Our Case Number: ACP-323066-25

Re: Gort Town Centre Public Realm Enhancement Project, Gort, Co. Galway
In the townlands of Gort, Co. Galway

Re: Case reference: JP07.323066

Gort Town Centre Public Realm Enhancement Project, Gort, Co. Galway

### 3.1 Market Square

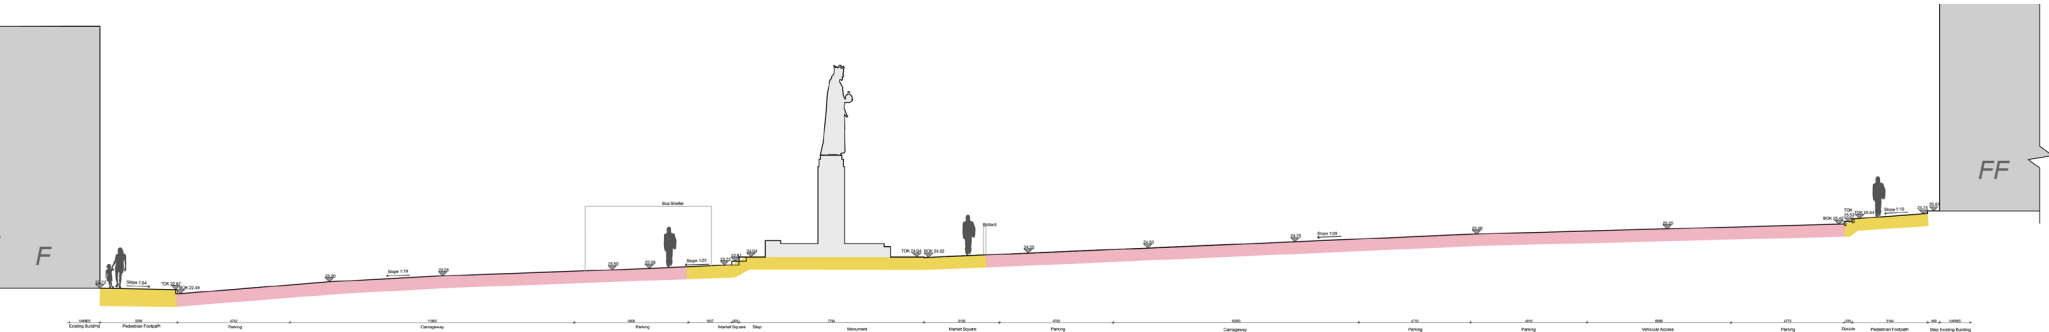
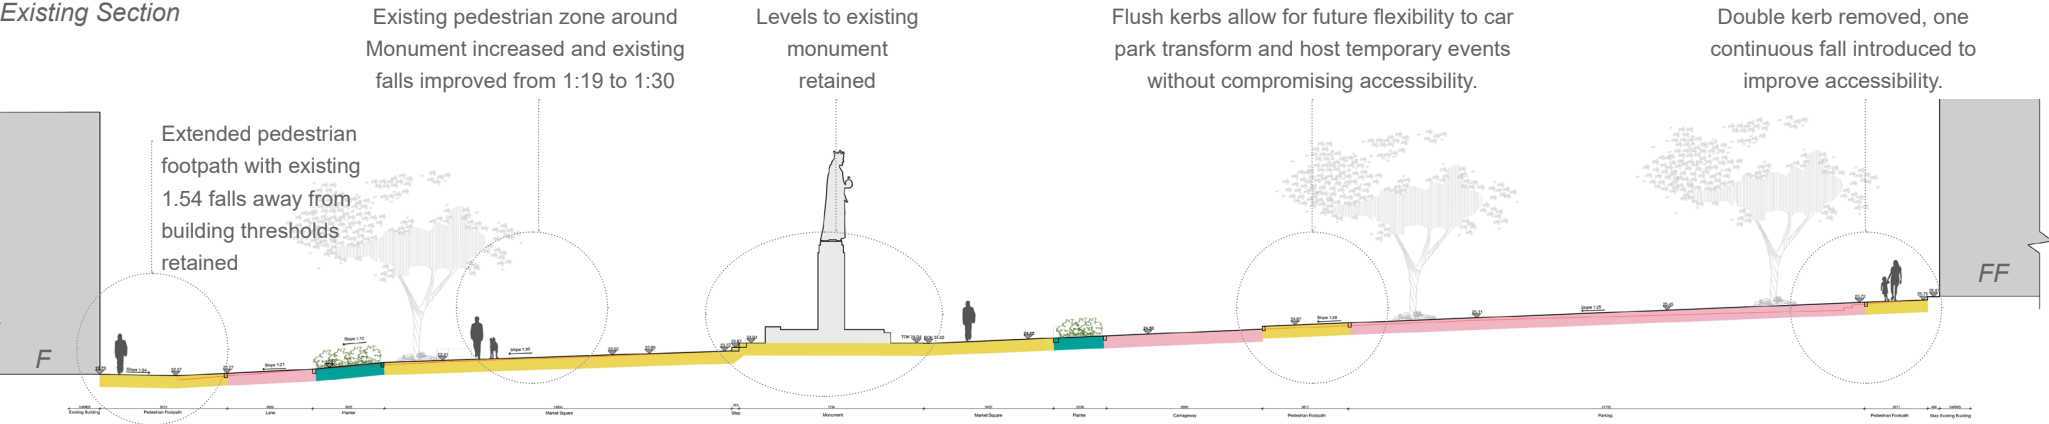
For the main square itself the designers have provided little by way of cycling provisions in terms of cycling facilities or improved (widened) roadway widths. There are some cycling ramps shown at the proposed roundabout. Apart from that it seems that road space is to be removed from bicycle users by narrowing the roadways to 6.4m. A welcome element of the scheme is that some of the current parking at Market Square is to be relocated elsewhere. That the space obtained was not then used to assist cyclists is regrettable. At the same time a large block of perpendicular parking is to be retained on the south side of the square with the main flow of traffic (and bicycle users) passing behind it.

It seems to me to be a highly questionable design decision to restrict the road space available for people on bikes, mix them with a heavy traffic flow and then also route them directly behind a long block of perpendicular parking spaces. In my view this design creates an avoidable risk of conflict with reversing drivers.

In my view the whole concept for Market Square should be refactored to provide for formal cycling provisions linking the east side of Gort with Crowe Street and Bridge Street. It might be that the perpendicular parking could be relocated to the north side and parallel parking provided on the south thereby reducing conflicts and providing space for cycling facilities.

### 3.7 Church Street

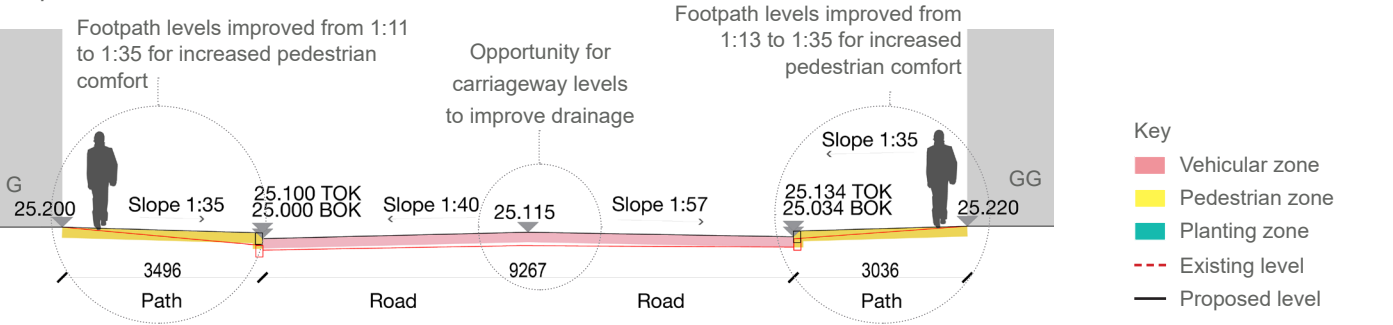
At Church St what is objectively happening is that road space is being removed from bicycle users, not to provide improved pedestrian provision, but to provide more car parking. According to the applicant's *Design and Planning Statement* the proposed design actions are as follows:

- The double carriageway width is tightened to 6.4m to calm traffic down and reduce vehicle speed.
- The pedestrian footpaths is retained as existing: 1.9m on the northern side of the street and 2.4m on the southern side. This is to allow the inclusion of on-street parking both sides of street.

The car parking being added makes up eight spaces. According to my calculations between the new car parks at Barracks Street and Crowe Street the final scheme adds 10 additional spaces to the existing parking stock in Gort. So these new spaces

In my view a more defensible use of the road space at Church Street is to remove the existing on-street parking and provide formal cycling facilities linking up with Market Square. In my view removing road space from bicycle users to increase the parking stock is not a supportable design.
